DELEGATED HOUSEHOLDER DECISION

Item No.	Report of the Head of Development Management and Building Control		
Address:	3 ACACIA AVENUE RUISLIP		
Development:	Construction of a part single-storey, part two-storey wraparound extension to the side and rear following the demolition of the existing garage		
LBH Ref Nos:	43839/APP/2024/3274		
Drawing Nos:	Existing Elevations & Floor Plans 201 B 202 B 300 400		
Date Plans received:	16-12-24	Date(s) of Amendments(s):	22-01-25
Date Application valid	16-12-24		22-01-25 22-01-25

Drawing Title:
PROPOSED PLANS
SCALE: 1:50 @ A1
Drawn by: ML
Drawing no: 201 rev B
Date: Dec 2024

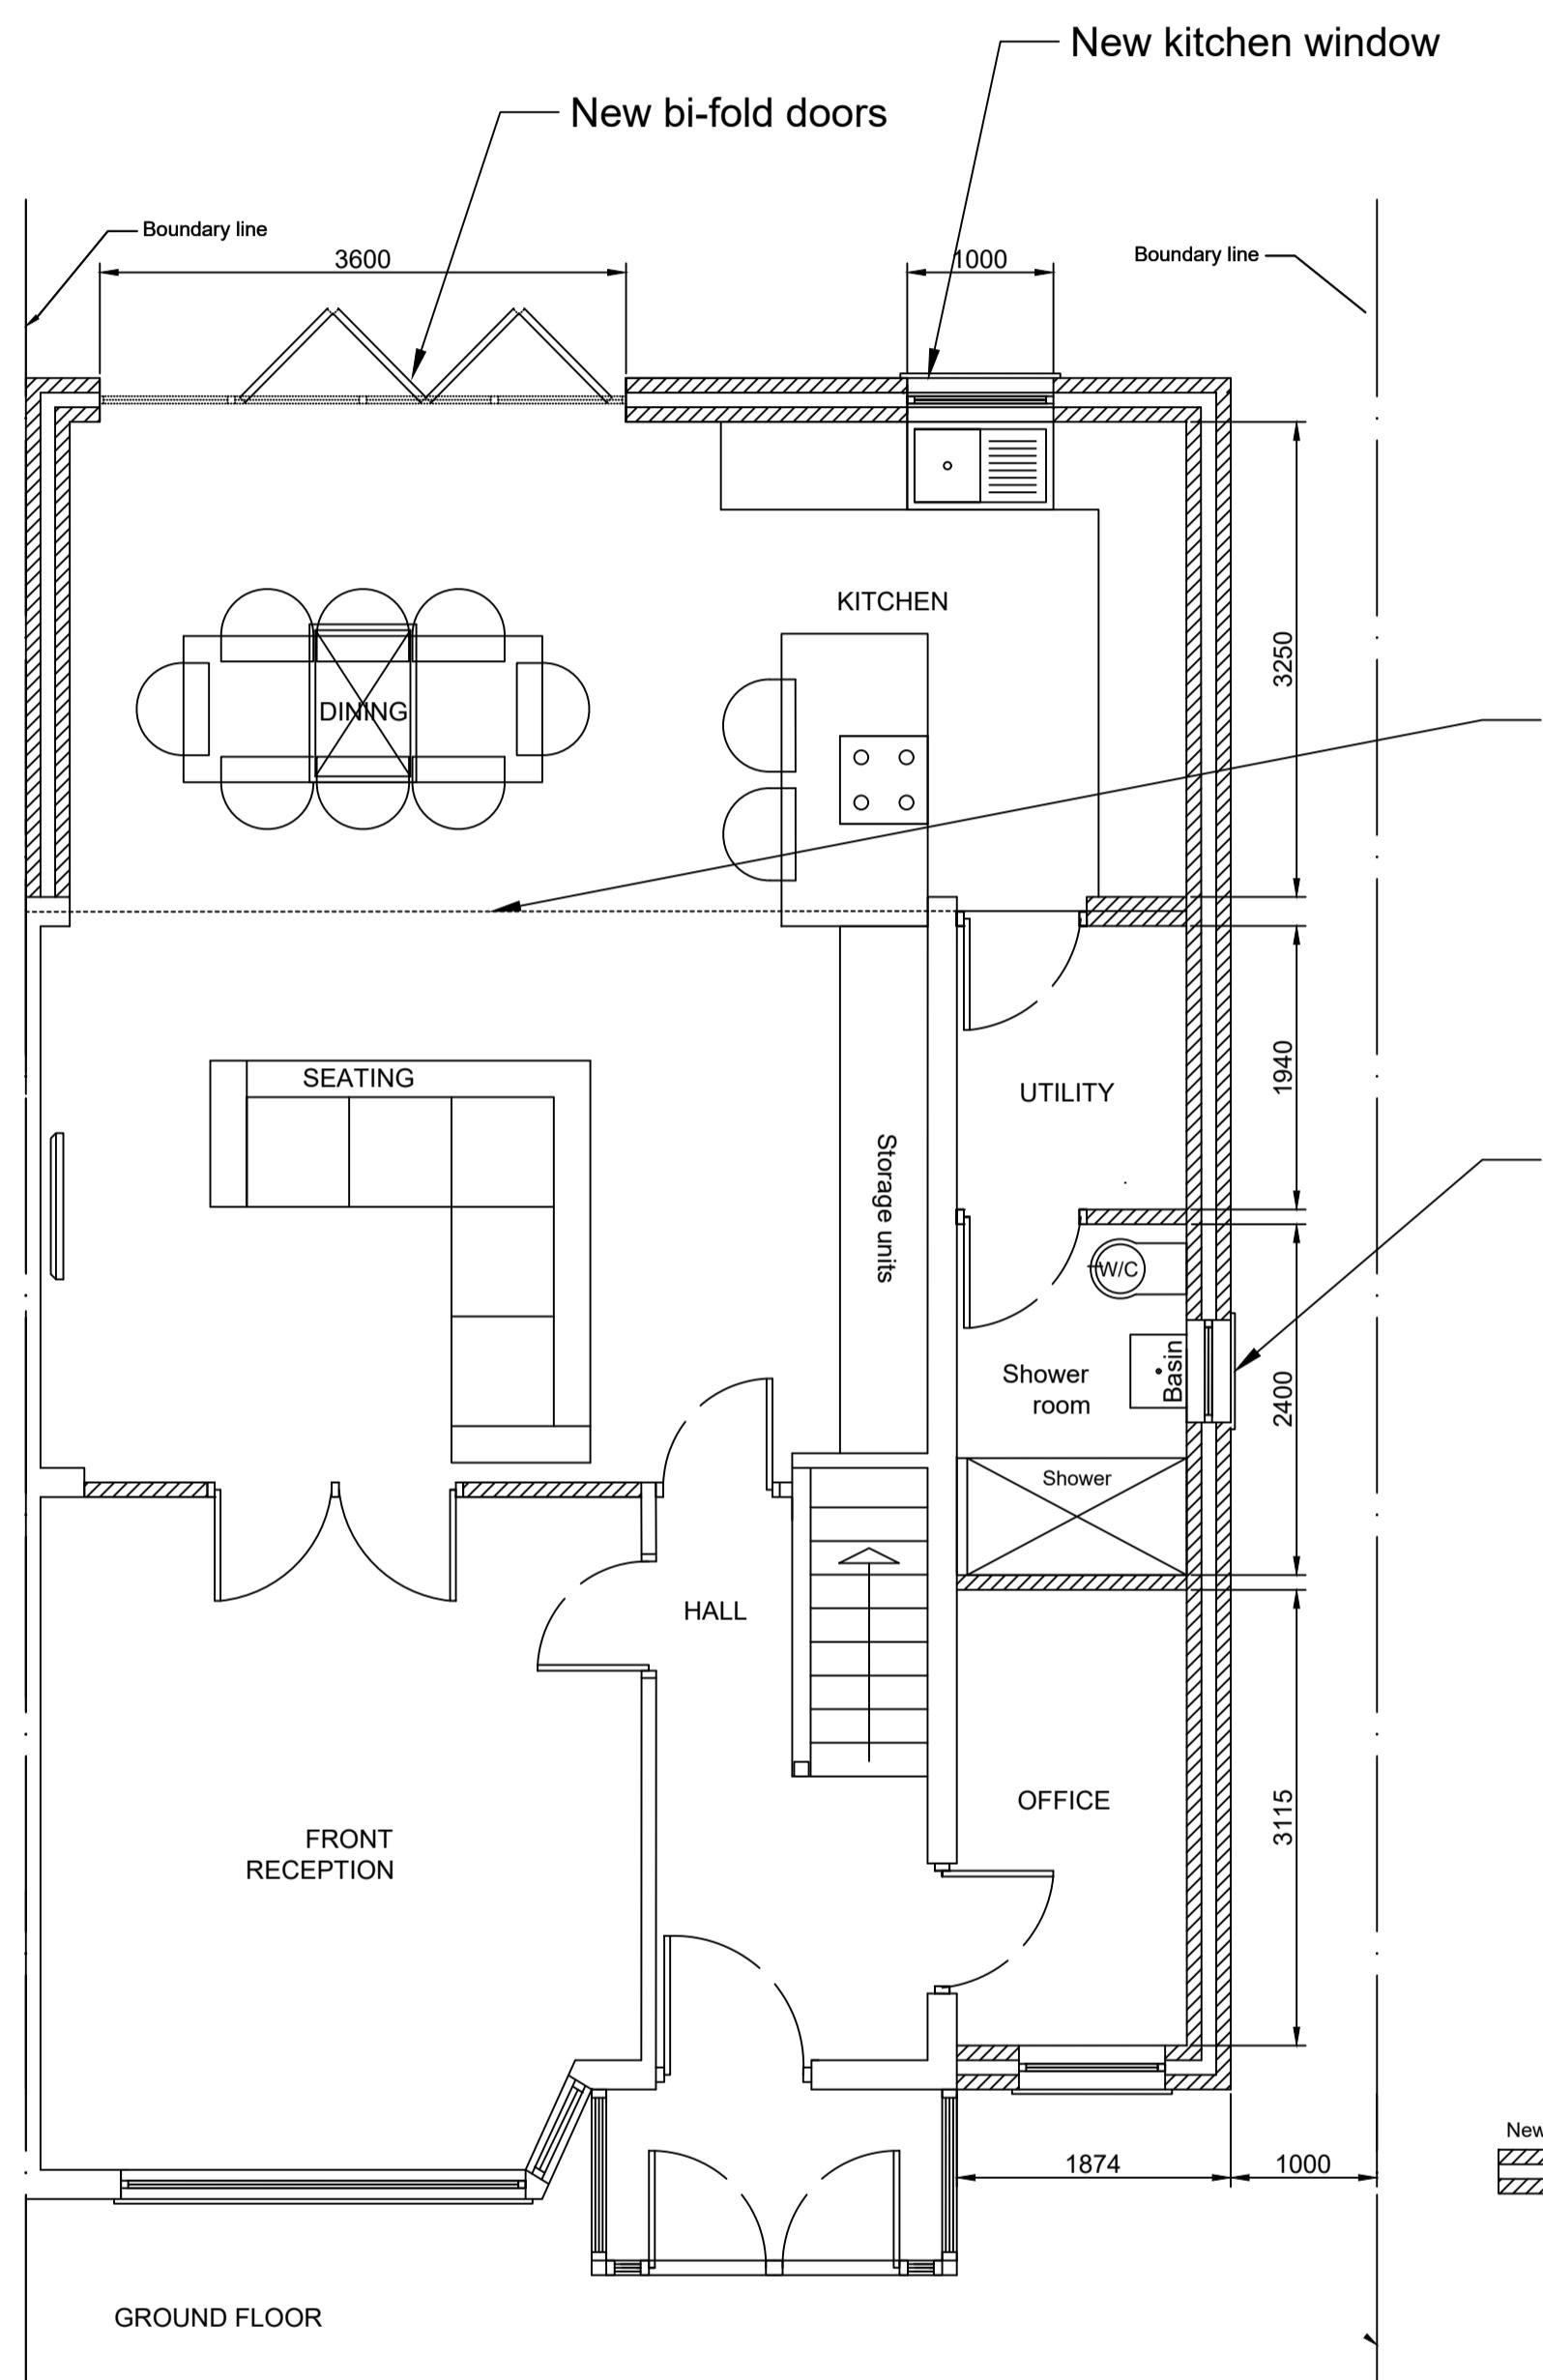
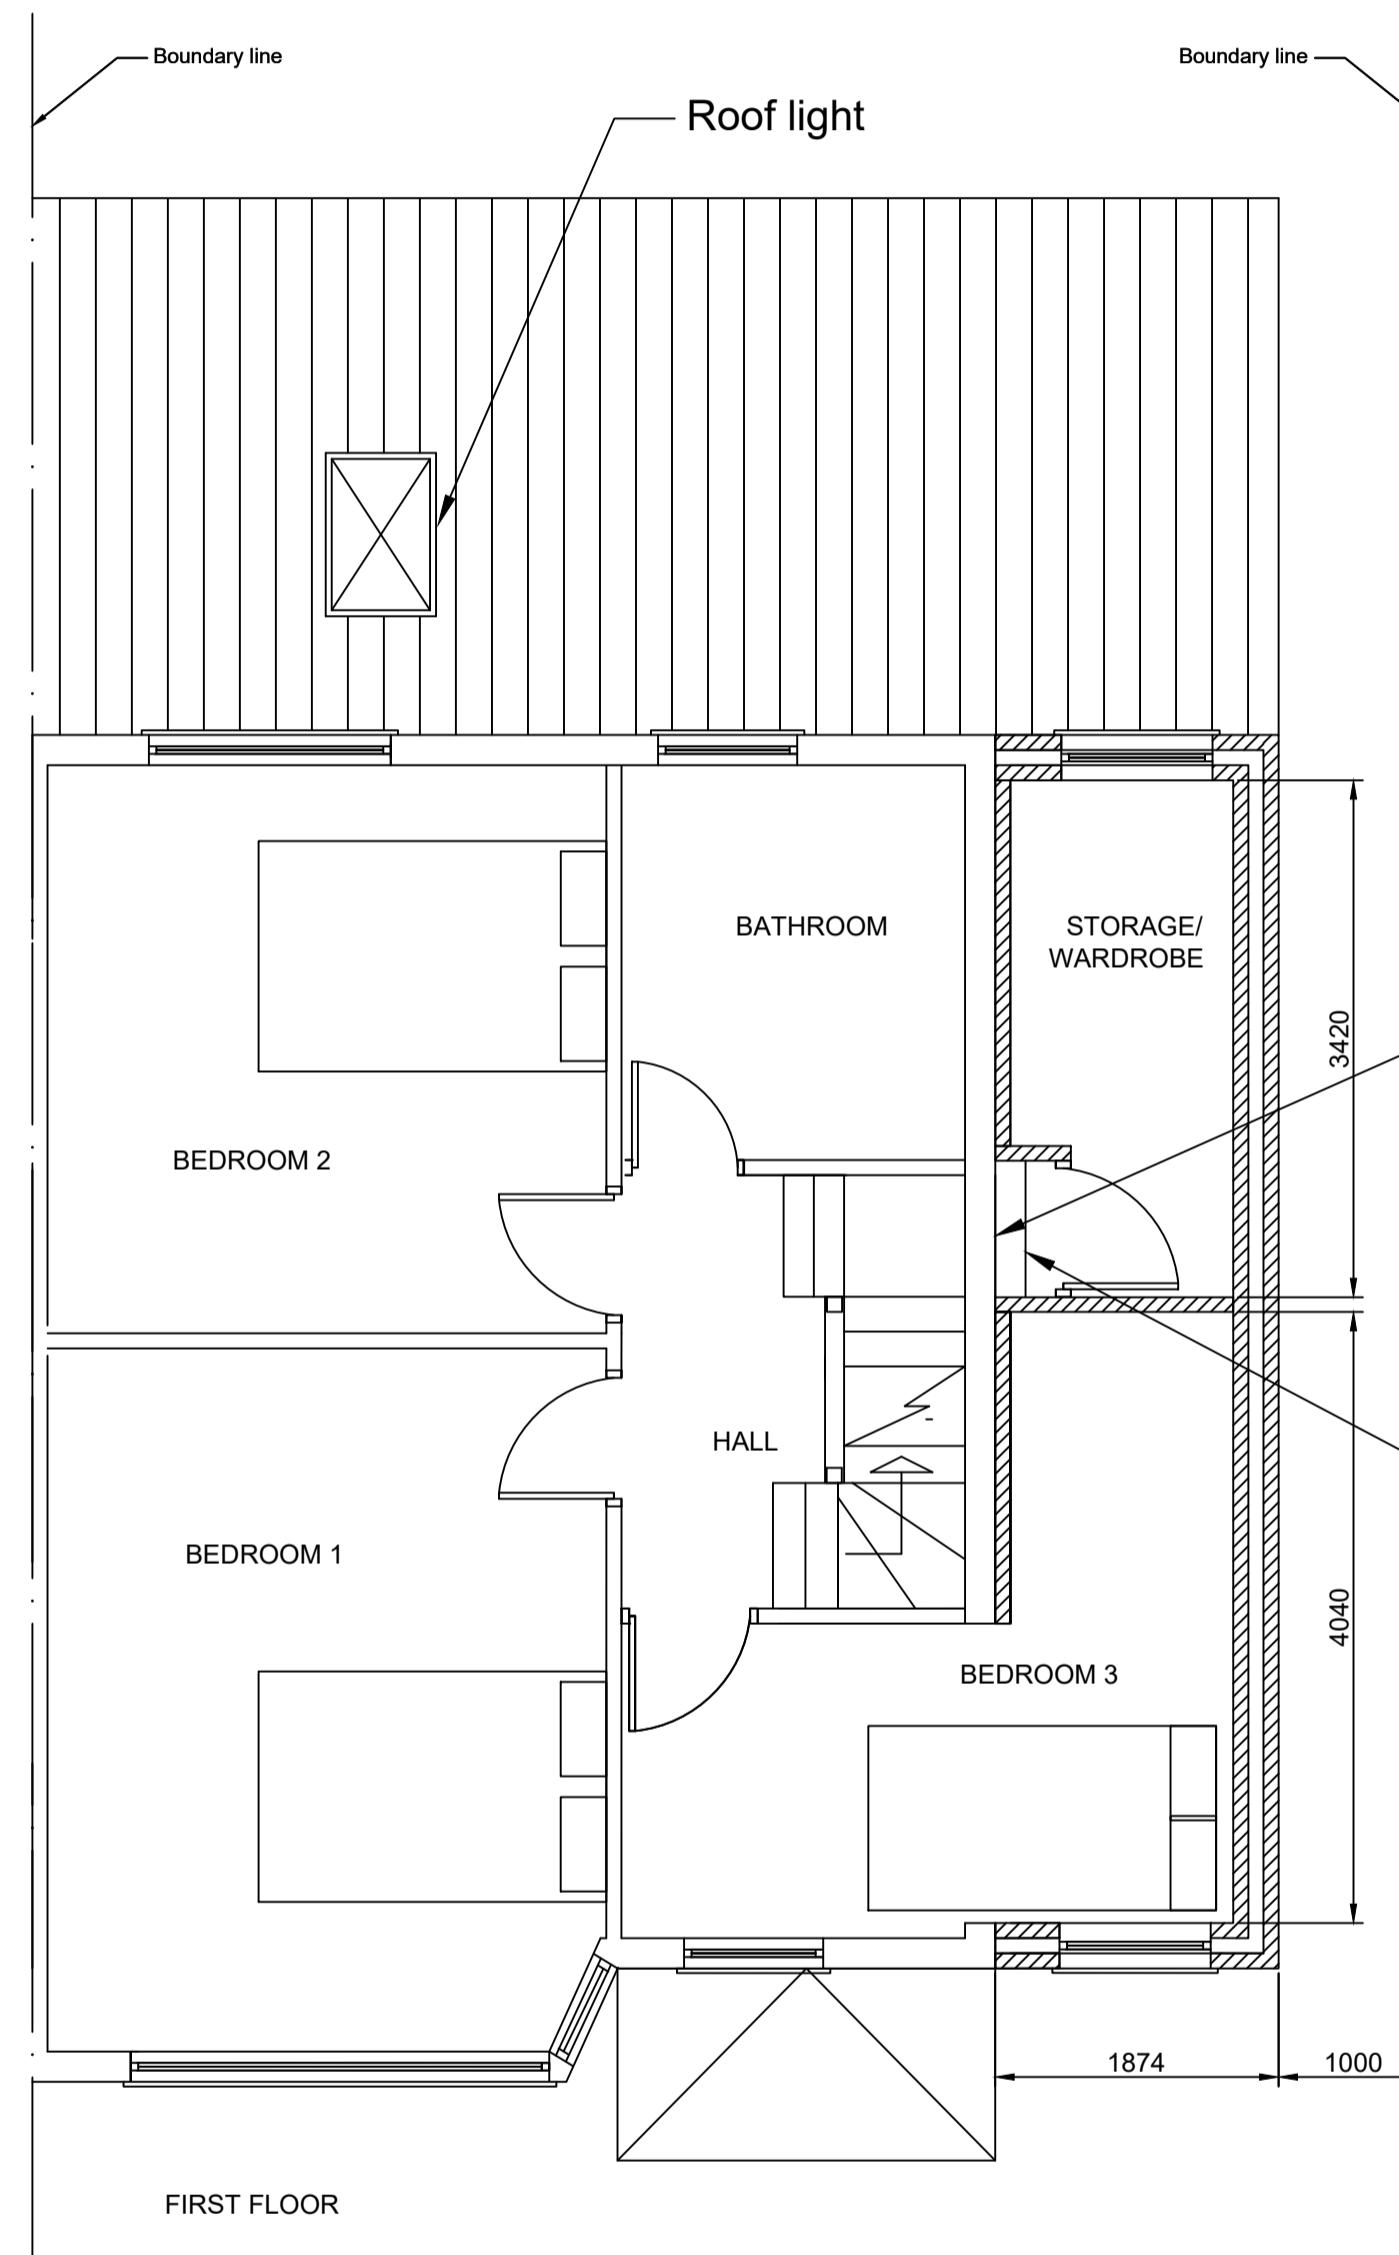
The two-storey side extension was originally proposed to be constructed on the side boundary; however, after receiving feedback from the local authority, the applicant submitted an amended scheme with the extension set in 1m from the side boundary in accordance with Policy DMHD 1. The extension would, therefore, be less than half the width of the original property and set back 1m from the side boundary. This would ensure the extension would be in proportion with the existing dwelling and maintain a good separation from the neighbouring property, avoiding any adverse impacts on the streetscape character. The extension would be set back 700mm from the front projecting bay window, but in this instance, the setback is considered acceptable as it would still be subordinate to the bay window feature and would create a consistent frontage with the existing setback entrance. The extension has been designed with a lower roof profile than the original dwelling, ensuring it would be subordinate to the original dwelling.

The proposed side extension would be visible to 5 Acacia Avenue, but the amended proposal includes a setback of 1m from the shared side boundary in compliance with Policy DMHD 1, addressing previous concerns over dominance and loss of daylight to the neighbour. The two-storey extension would not extend past the existing rear building line of the application site, which is approximately the same as that of 5 Acacia Avenue, and as a result, would not intrude into the 45-degree line of sight from the rear windows of the neighbour, ensuring it would not be overly dominant or bulky. Given the 1m setback and the fact that the application property is located slightly north of 5 Acacia Avenue, no undue harm would befall the daylight and sunlight access of the neighbouring dwelling. The proposed single-storey rear complies with Policy DMHD 1 with respect to the height and depth of the extension and would be set back 1m from the shared boundary. As a result, the extension would not be overly dominant or bulky to the neighbouring occupiers, nor would it unduly impact daylight & sunlight access to the neighbouring property.

The application removes an existing first-floor flank window facing 5 Acacia Avenue. A new flank window is proposed at ground level facing 5 Acacia Avenue; however, this is proposed to be obscure-glazed, would not serve a habitable room (only a bathroom), and the outlook from the window could be readily blocked by boundary fencing. As such, the application reduces overlooking 5 Acacia Avenue and would not unduly harm their privacy. A condition is attached, requiring the flank window to be obscurely glazed. As such, with the inclusion of appropriate conditions, there would be no undue harm to the daylight, privacy, outlook, or other amenities of 5 Acacia Avenue caused by the proposal.
